## COMMUNITY SERVICES DEPARTMENT

December 29, 2020

Subject: **Bent Grass East Commercial Filing No. 3 Preliminary Plan (SP-20-010)**

BENT GRASS EAST COMMERCIAL FILING NO. 3			
PEDESTRIAN ACCESS EXHIBIT			
DESIGNED BY	MAW	SCALE	DATE 8/30/21
DRAWN BY	MAW	(H) 1" = 30'	SHEET 1 OF 1
CHECKED BY		(V) 1" = N/A	JOB NO. 2177.64

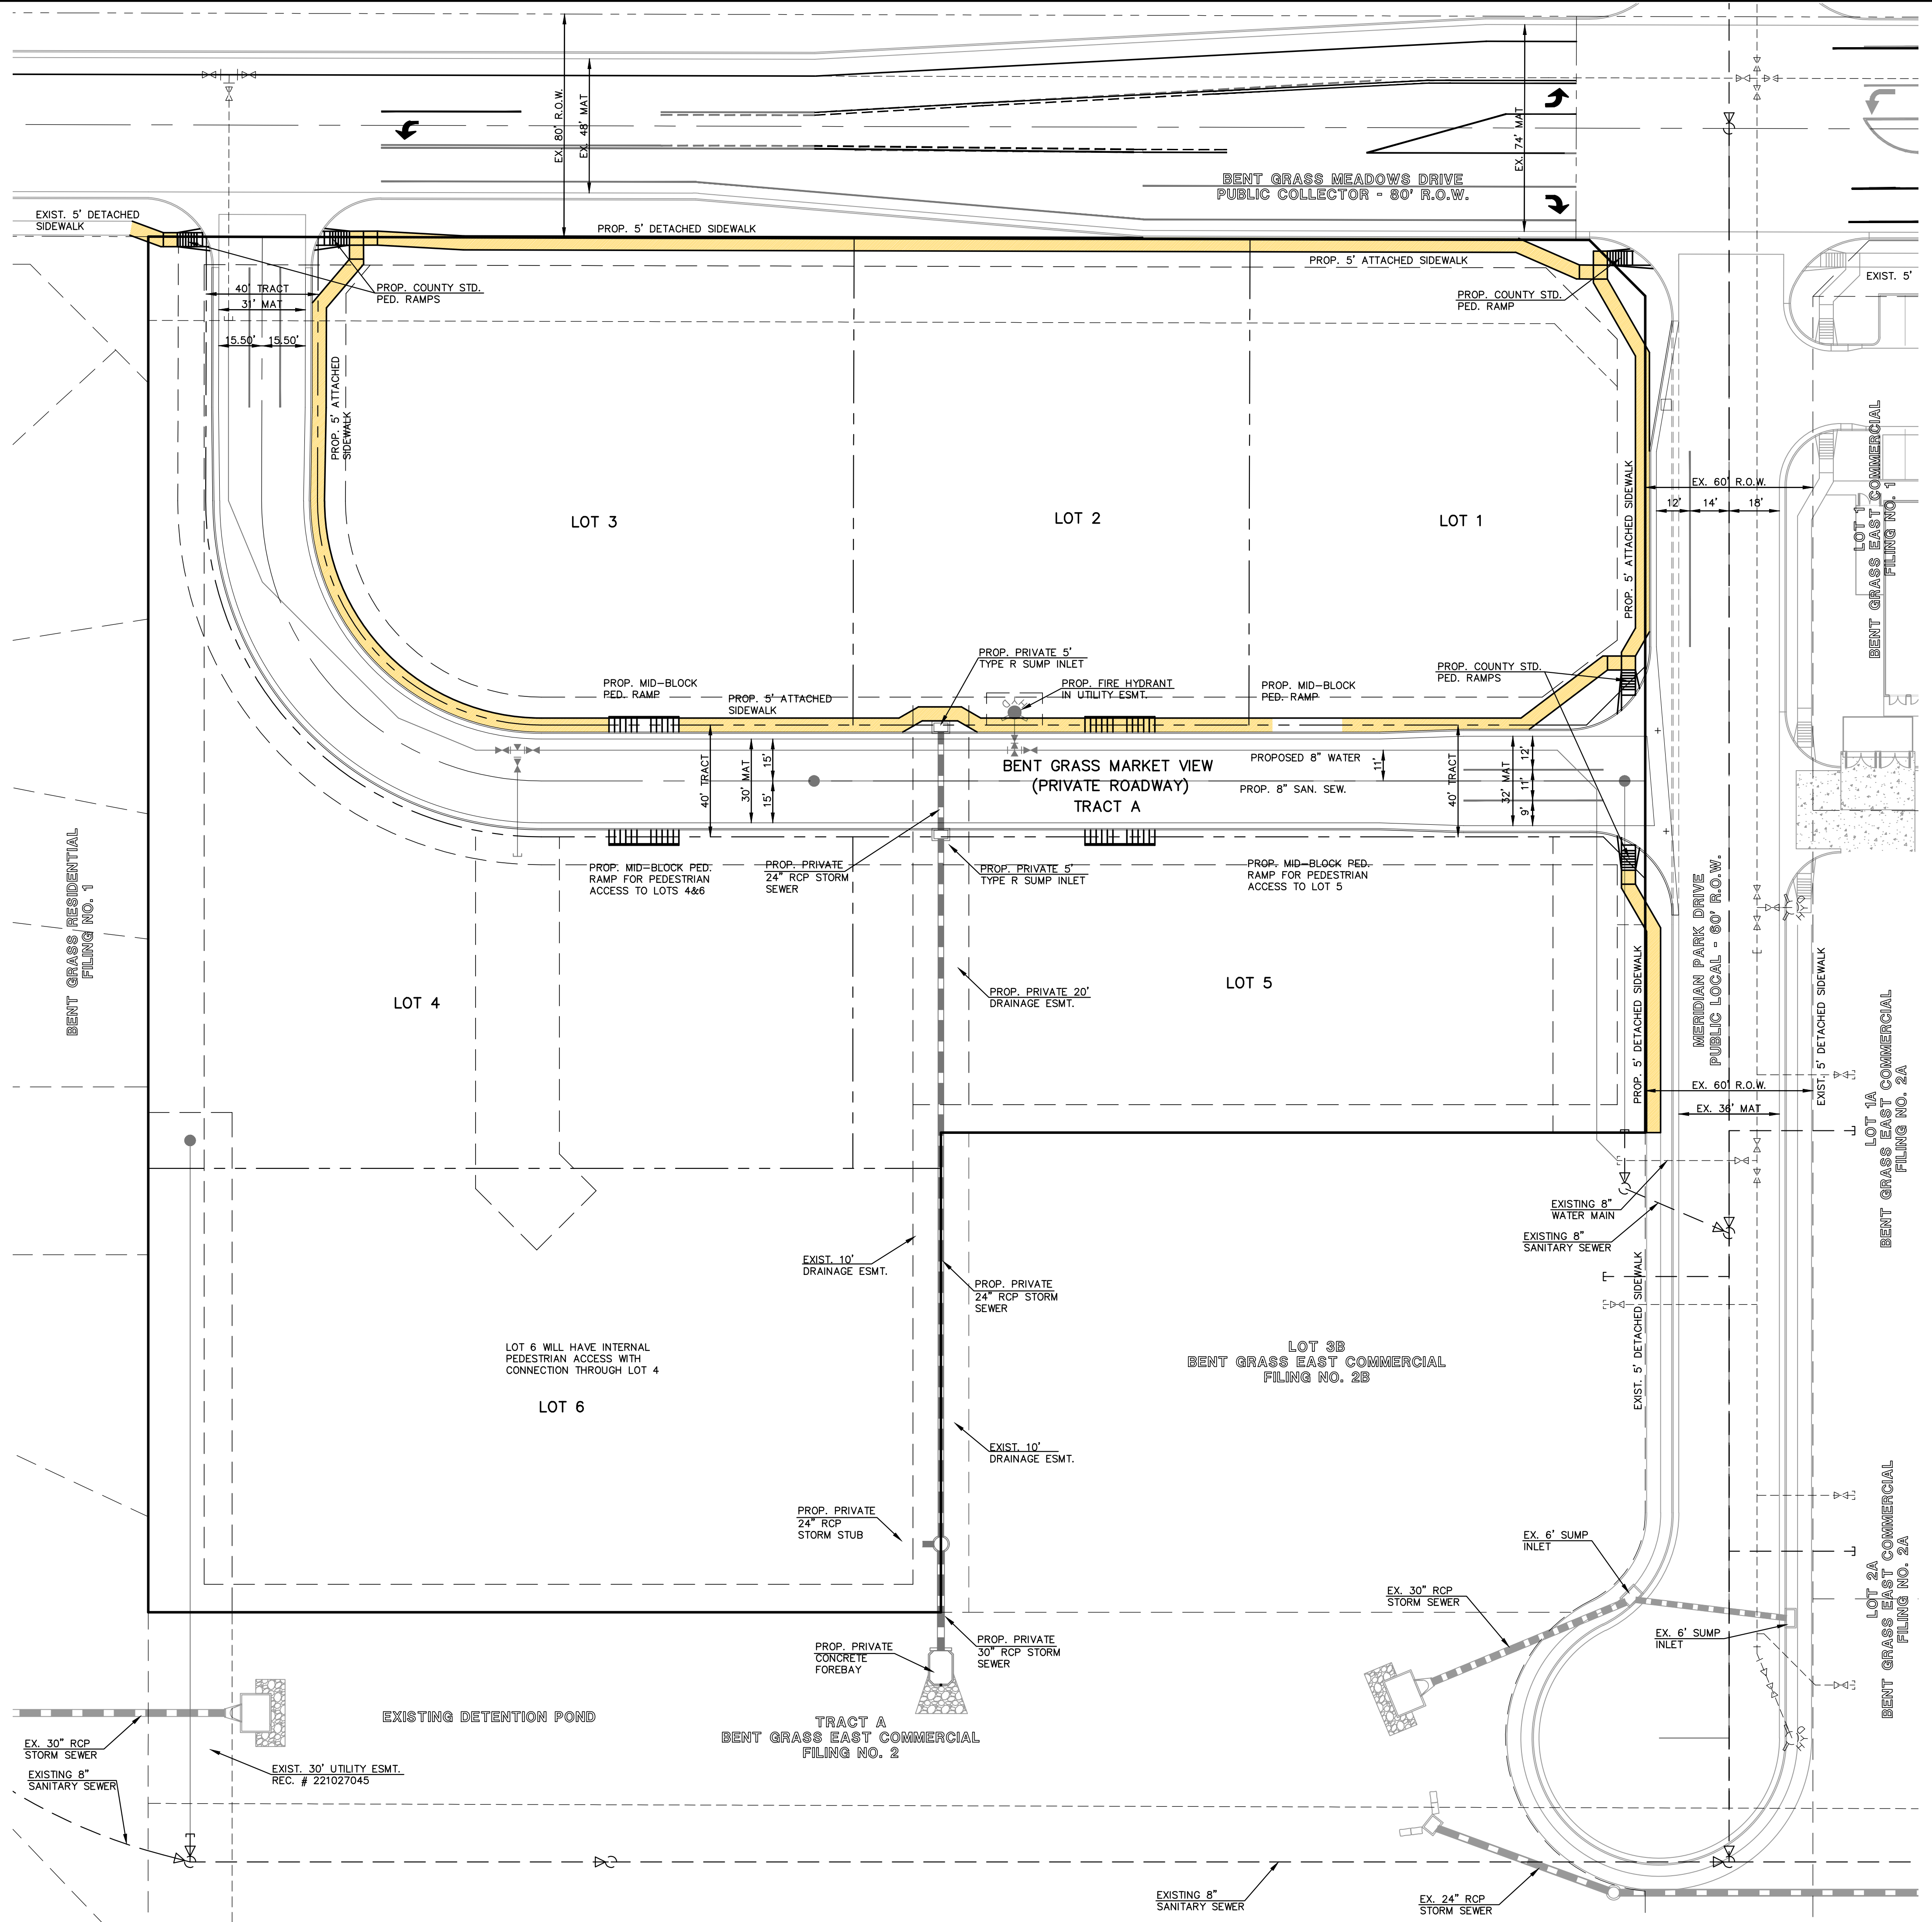
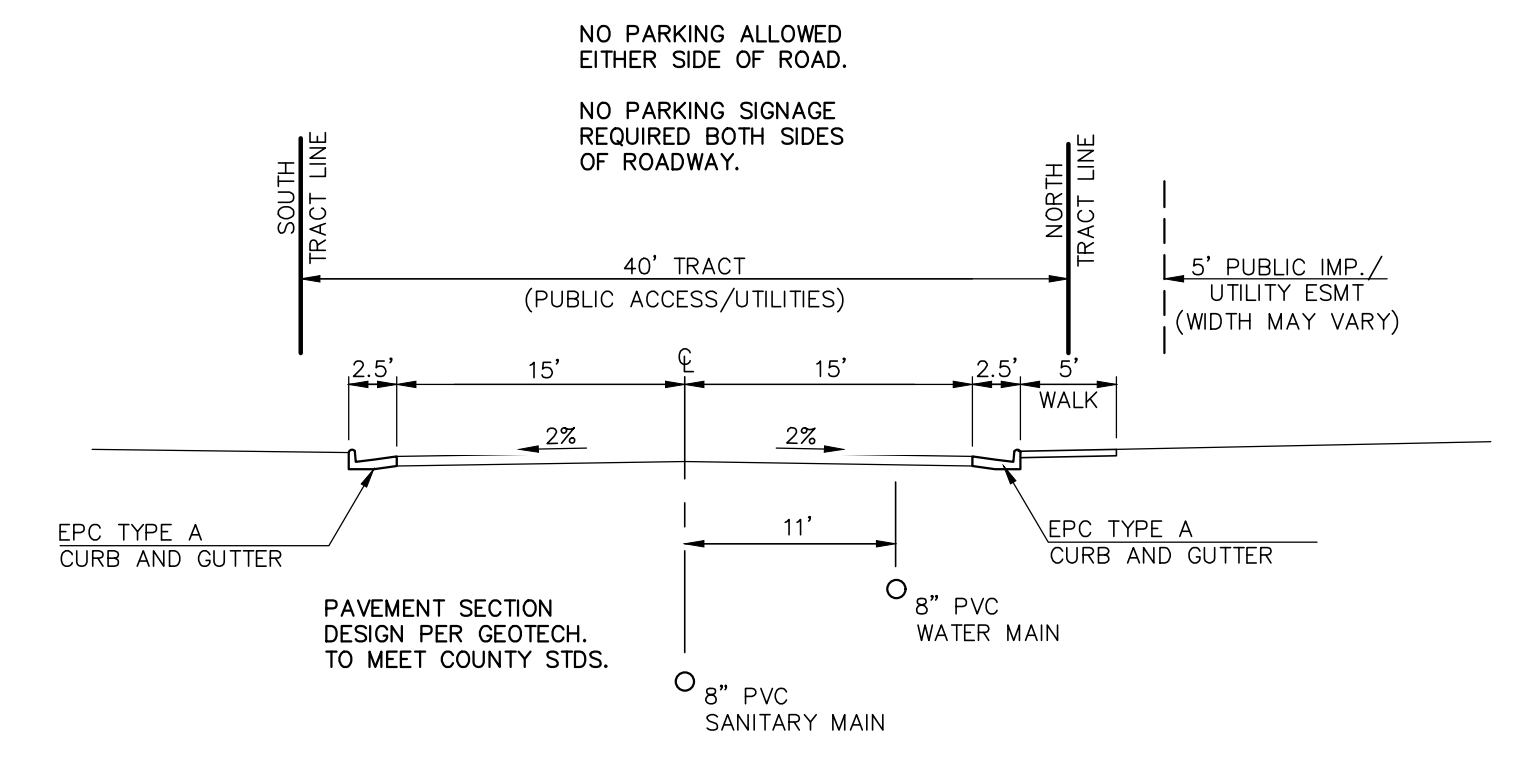
Due to the inclusion of a proposed 8' concrete sidewalk along the west side of Meridian Road, as drawn and noted in the Bent Grass Meadows Drive/Meridian Road Intersection Improvements Construction Drawings (CDR-19-004), Parks staff highly recommends that the applicant include the Bent Grass Meadows Drive sidewalk drawings and details in the Preliminary Plan and forthcoming Final Plat and Construction Drawings. While seemingly a minor detail, this sidewalk will allow for safe and efficient pedestrian connections between the Bent Grass community and commercial opportunities along Meridian Road.
